Application No: LU/55/22/L

Site Address: The Flintstone Centre East Street Littlehampton BN17 6AW

Description of works: Listed building consent for the installation of 3000mm high welded mesh fencing and associated single leaf gate along a section of the northern boundary line and along the rear elevation, Ornamental fencing and associated gates to be installed, located adjacent to the existing southern side entrance to the building, as well as the installation of 3000mm high welded mesh fence encapsulating the existing boiler room to the rear of the building, demolition of existing side secondary entrance including existing ramped access and associated fittings. Repairs to the section of wall affected by the removal of the entrance.

Thank you for your internet representation made on 8th March 2022 which has been recorded as an objection with the comments as follows:

Title:
THE FLINTSTONE CENTRE
FENCING LAYOUT AS PROPOSED

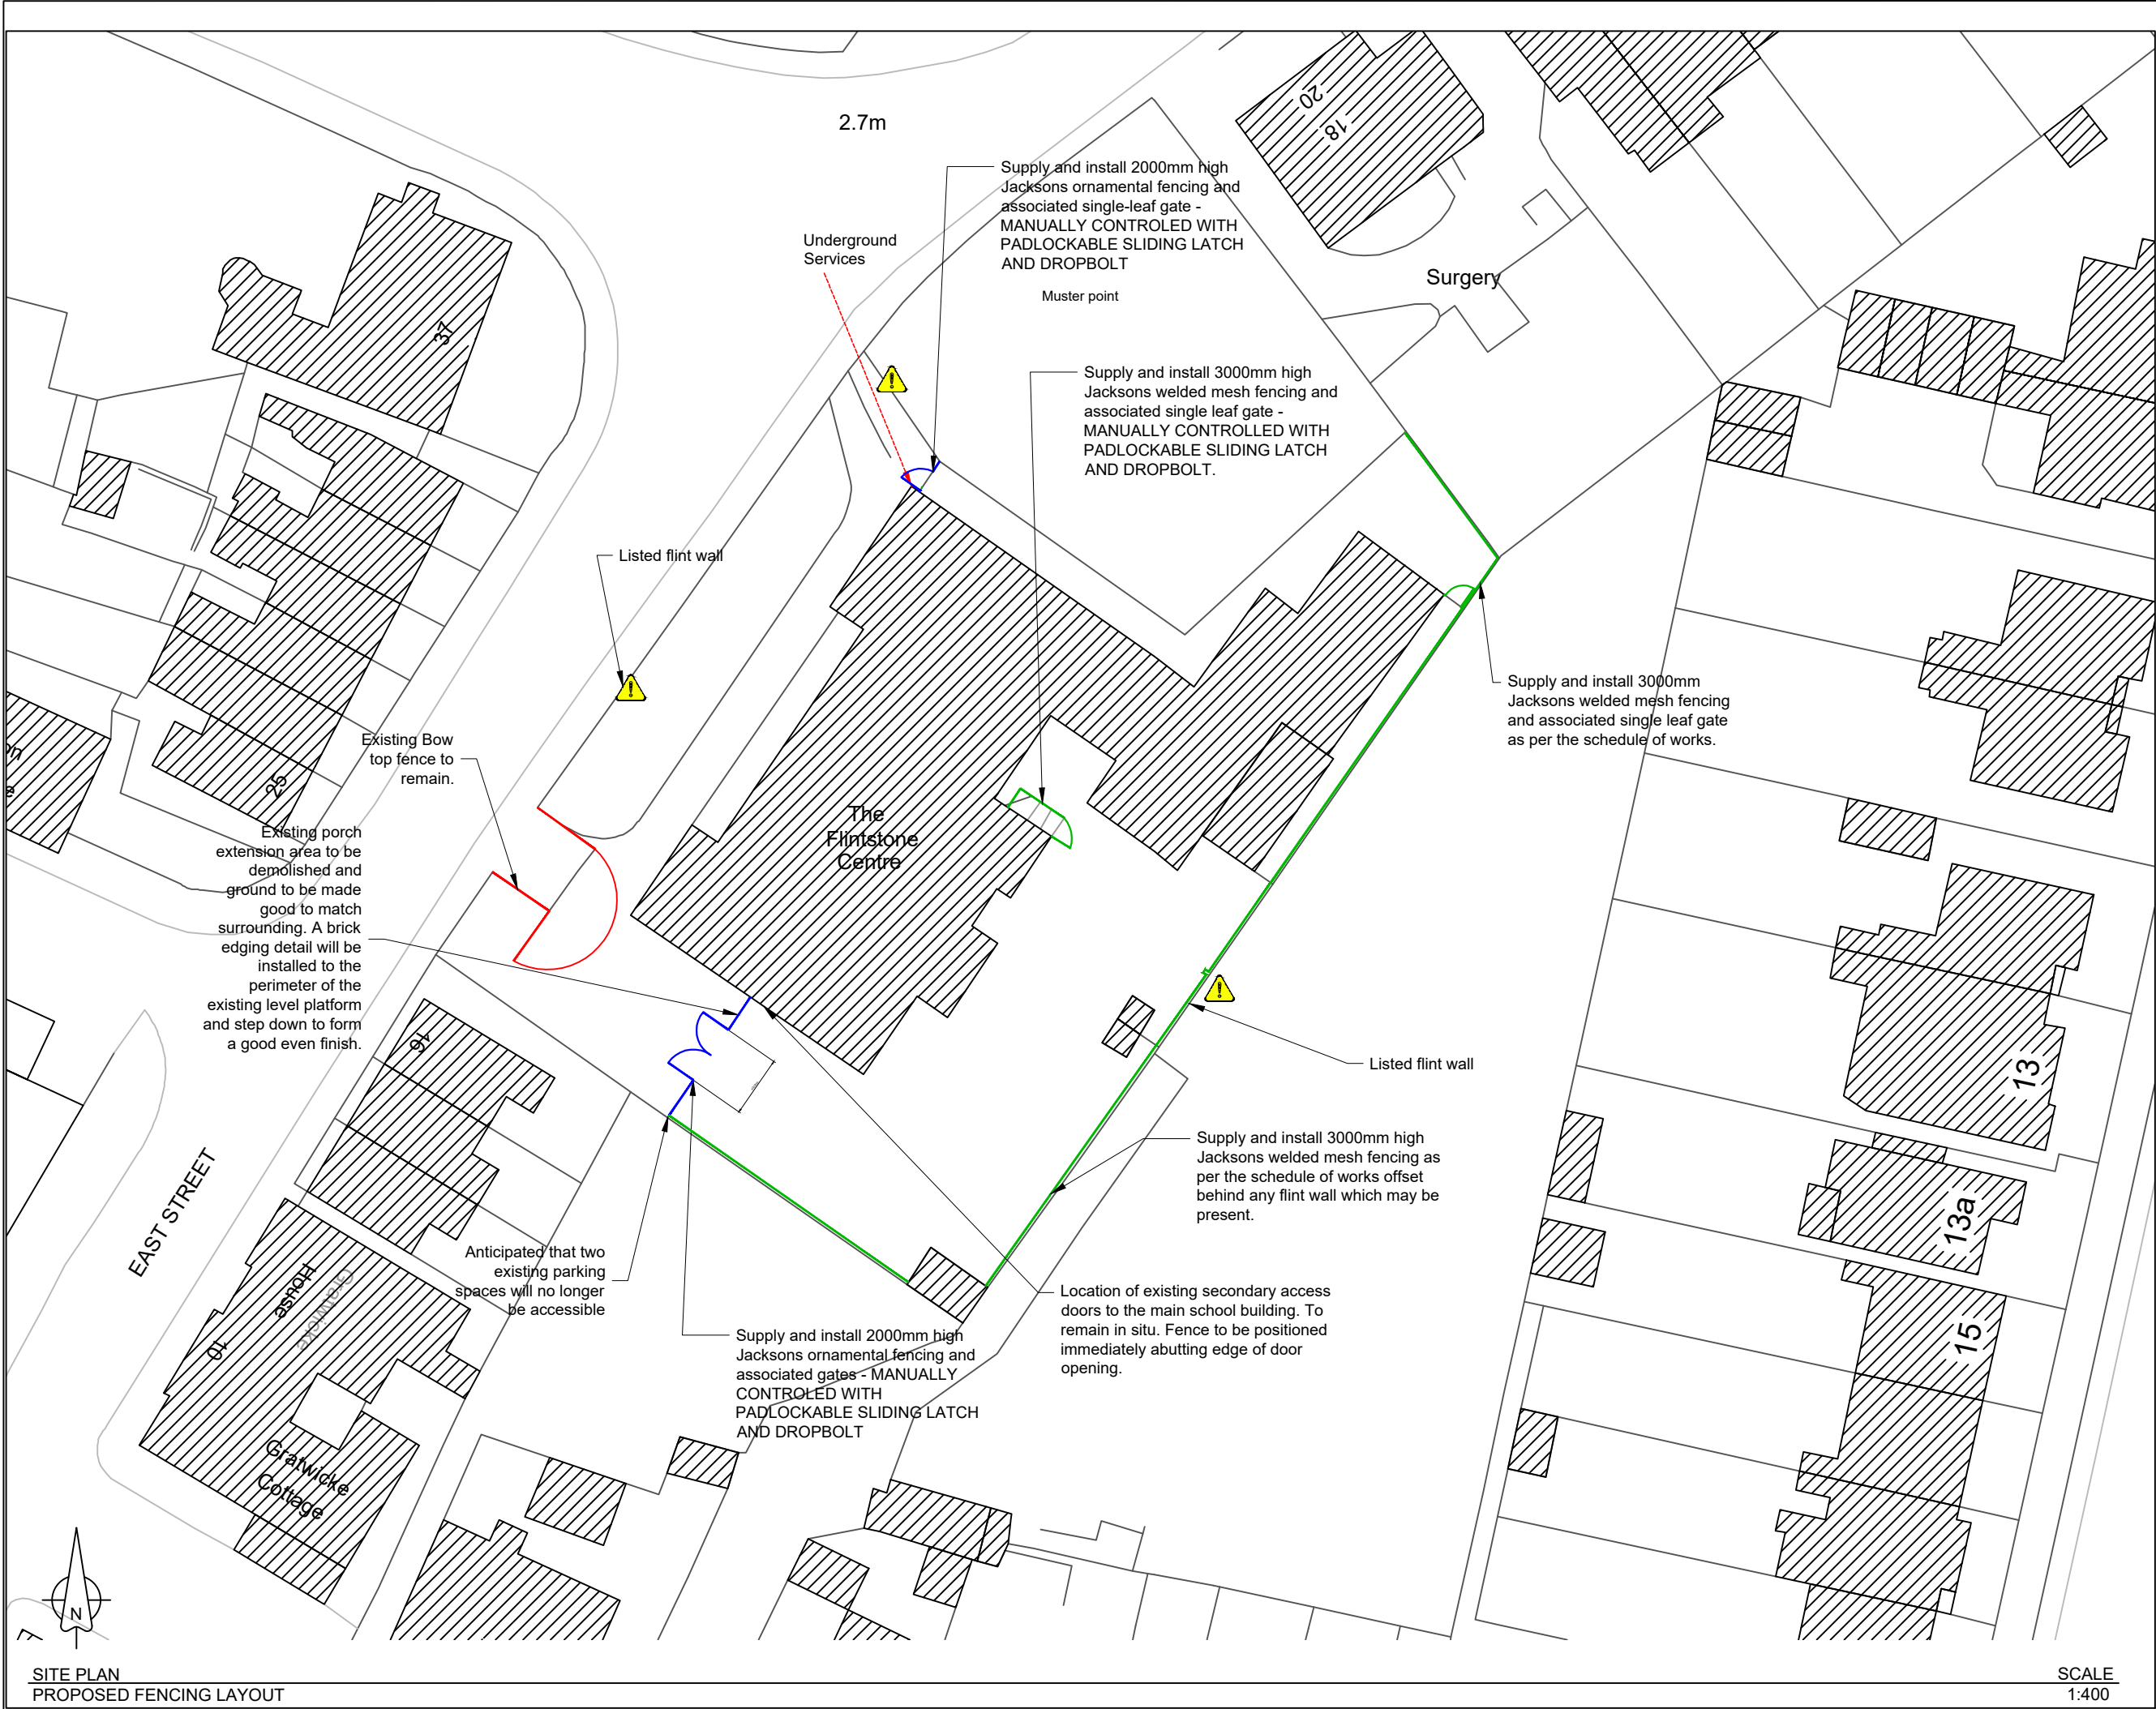
Firstly, I am supportive of a fence to the rear of the Flintstone Centre to improve the security of the premises BUT not in its current proposed form.

I note that the planning application mentions that the front elevation is to have a (2m) black ornamental style fencing (and gates) to reduce the visual impact of the fencing from a street view. The application also mentions that green welded mesh fencing is to be erected to the rear of the building as it is not visible from a street view. The planning also states that the sections of fencing to the rear is considered acceptable given their limited visibility. There appears to be little consideration of the Old Dairy Farm residents who will have this green (3m) high weld mesh fence as a permanent outlook to their properties rather than a passing view to the front of the Flintstone Centre. I also cannot see where the Heritage Statement has considered the close proximity of the Old Dairy Farm properties to the rear fence. It would be erected within approx. 10m of the front of a number of the properties at The Old Dairy Farm, protruding above the existing flint wall, and also alongside the whole garden wall of number 8. The rear fence in its current form will be ugly as well as inappropriate for a conservation area. The Old Dairy Farm development had to comply with a number of planning obligations due to it being in the conservation area including that of a Heritage style entrance gate and fence as well as Heritage style lamp posts (all adjacent to the Flintstone Centre rear flint wall). I also point out that the rear fence is to enclose the car park so not a playground or other area where pupils should gather due to the inherent health & safety risks of the car park. I have also personally been in regular contact with the planning agent firm during the revised planning process and had previously been informed by the Project Lead that the rear fence would be a black Heritage style metal fence so in keeping with the conservation area

and more acceptable for those Old Dairy Farm properties and residents that are in close proximity of it. I am now concerned to find out that this is not the case. I would however be supportive of a black Heritage style fence to the rear.
